MMO Reference: DCO/2023/00007  
Planning Inspectorate Reference: EN010128

**Planning Act 2008, Cory Environmental Holdings Limited (CEHL), Proposed Cory Decarbonisation Project Order**

**Deadline 1 Submission**

The Applicant seeks authorisation for the construction, operation, maintenance and decommissioning of a carbon capture facility, including supporting plant and ancillary infrastructure.

Figure 1: Sediment Sampling Locations in Accordance with the Agreed Sampling plan (Case Reference: SAM/2024/00042)

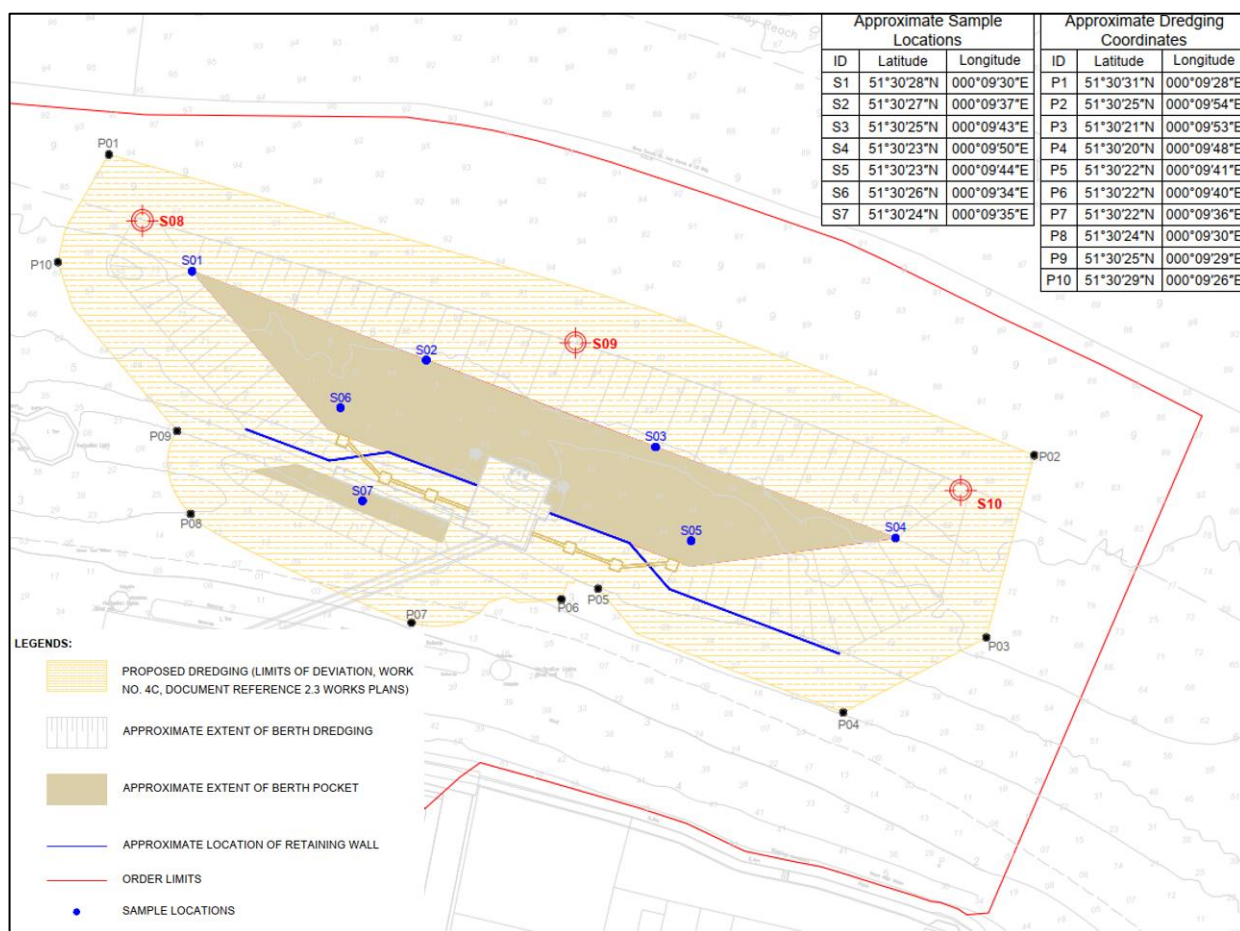
- 3.2.4. The MMO notes from the Change Request and Consultation Report that the Applicant made a commitment to complete additional sediment sampling at

depth across the proposed dredging profile, as per SAM/2024/00042. We further note that a disposal site will be selected upon review of the sample results. The MMO therefore considers the provision of the results is likely to address some of the previous concerns raised in our Relevant Representation, pending completion of the sample plan consultation.
